Cush Wind Farm

## Annex 13.1: Road Safety Audit

Stage 1 Road Safety Audit

December 2022

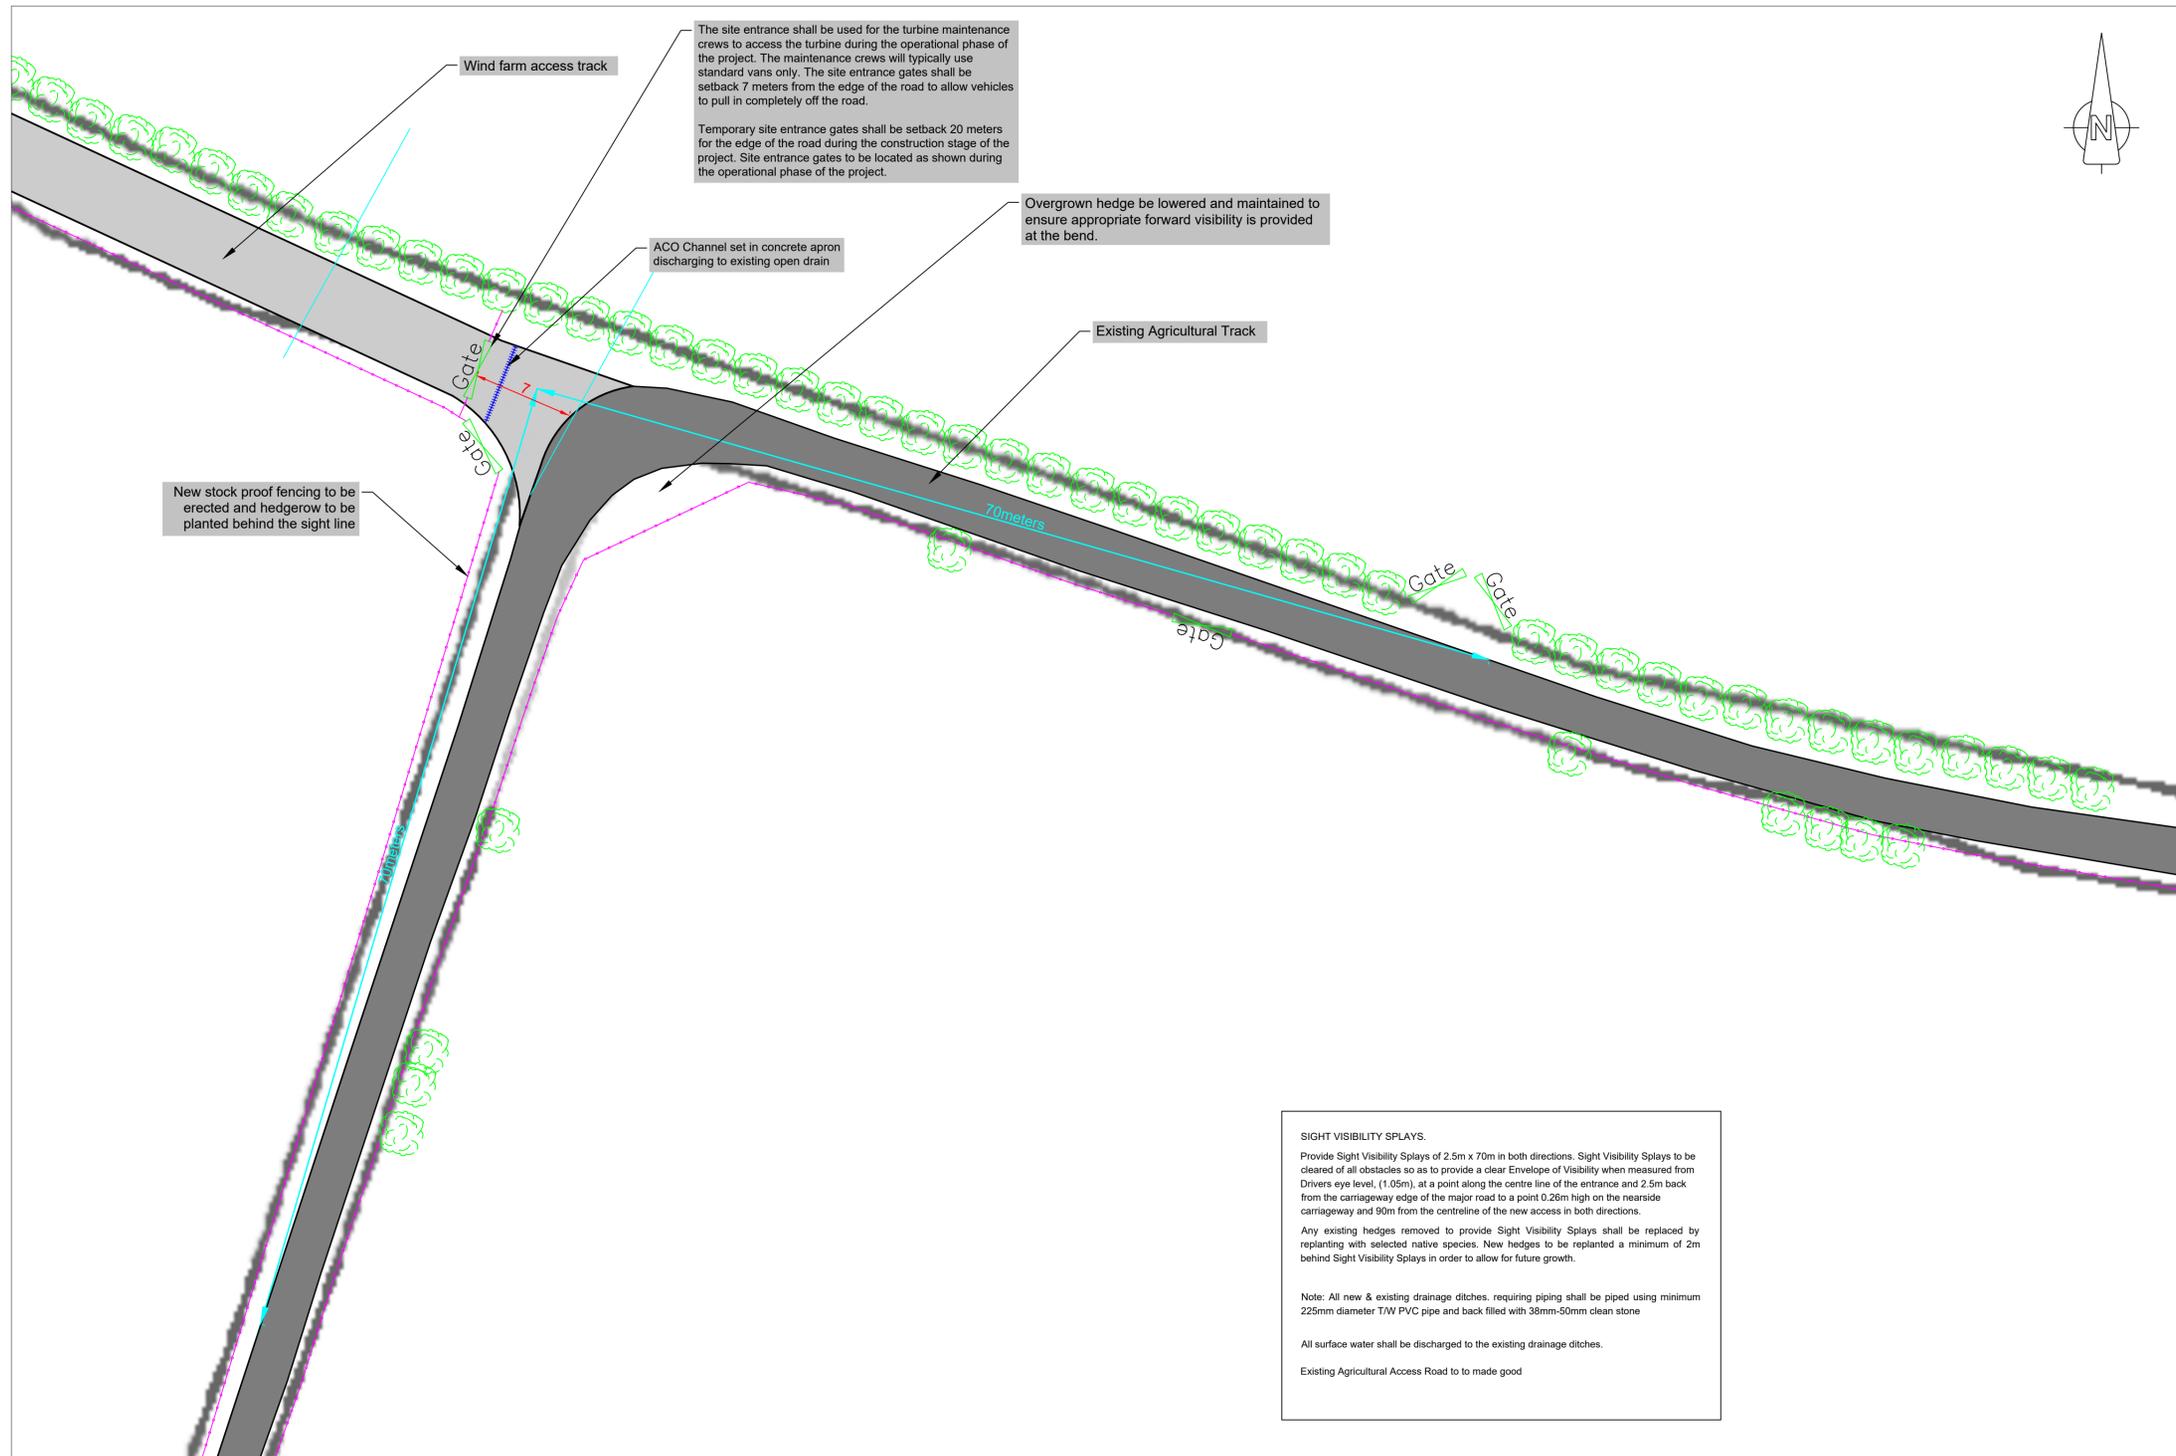
Location: N52 / N62 Junction

The abnormal load reversing manoeuvre could cause unexpected delay and sudden vehicle stops on the N52 & N62 National Road mainlines resulting in vehicle conflicts.

Appropriate traffic management should be deployed to provide short 'All Stop' at an appropriate location on the N52 & N62 National Road mainline approaches.

2.1	YES	YES	Appropriate traffic management will be deployed to provide short 'All Stop' at an appropriate location on the N52 & N62 National Road mainline approaches.

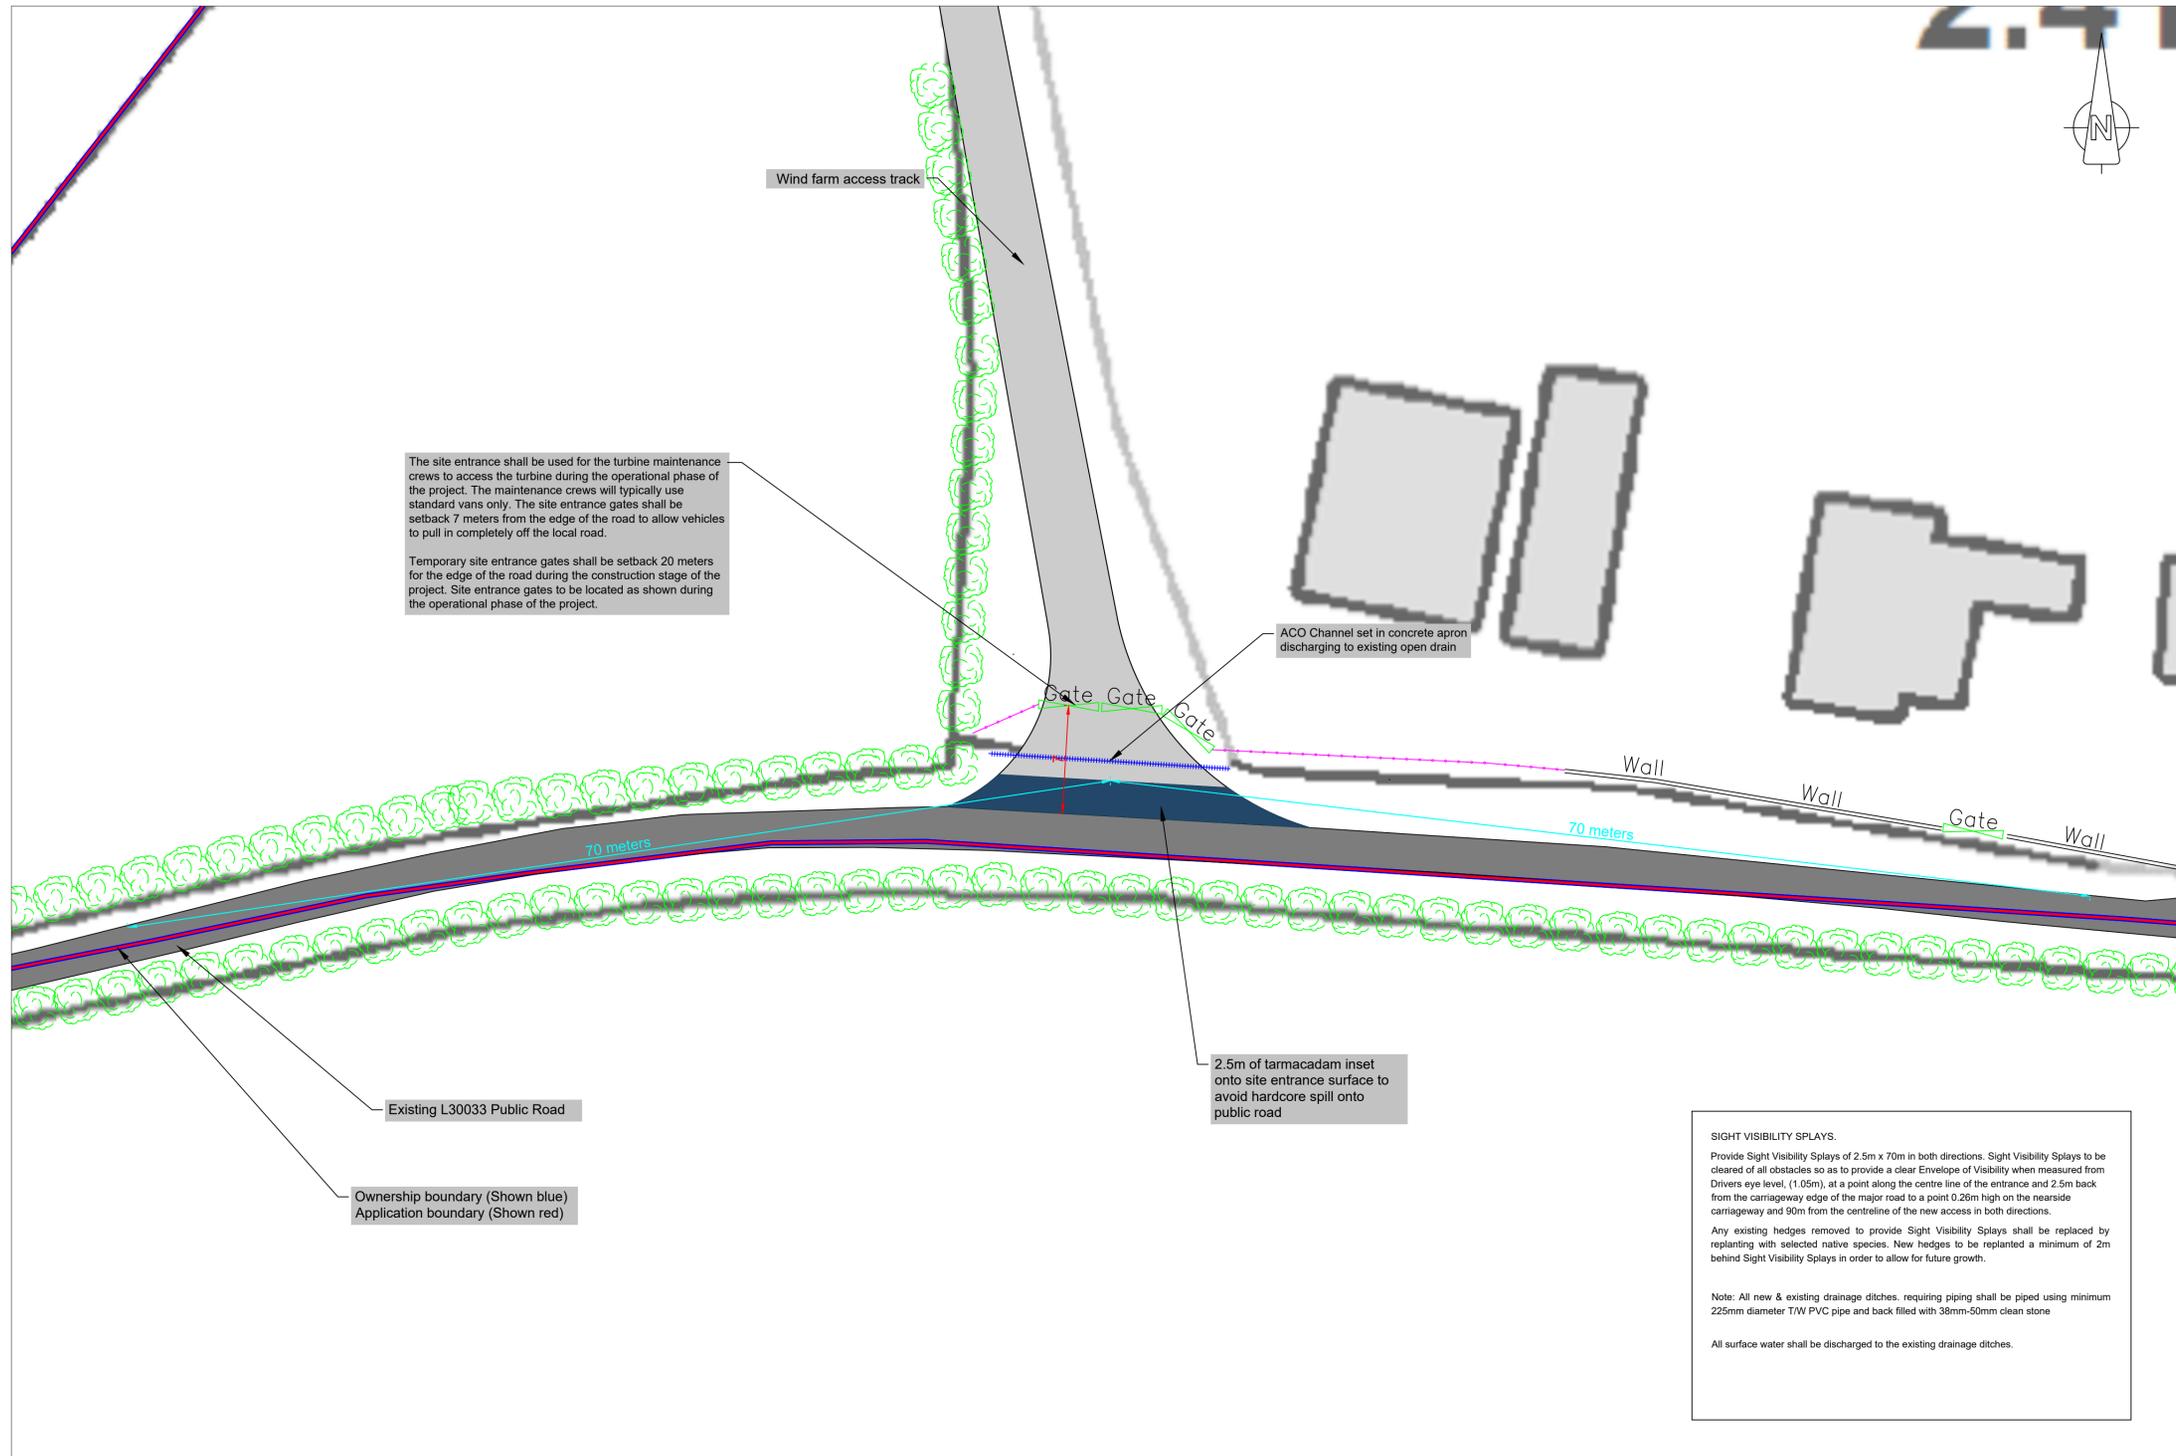
Location: Operational Site Entrance (East) & Operational Site Entrance (West)

The gate setback may not be sufficient for large operational vehicles to pull in completely off the road leading to conflicts with approaching vehicles.

The gates should be in-set an appropriate distance to ensure that the largest expected size operational vehicle can pull in completely off the road.

2.6	YES	YES	The overgrown hedge on the local road will be lowered and maintained to ensure appropriate forward visibility is provided at the bend.	
2.7	YES	YES	The entrance gates will be in-set an appropriate distance to ensure that the largest expected size operational vehicle can pull in completely off the local road.
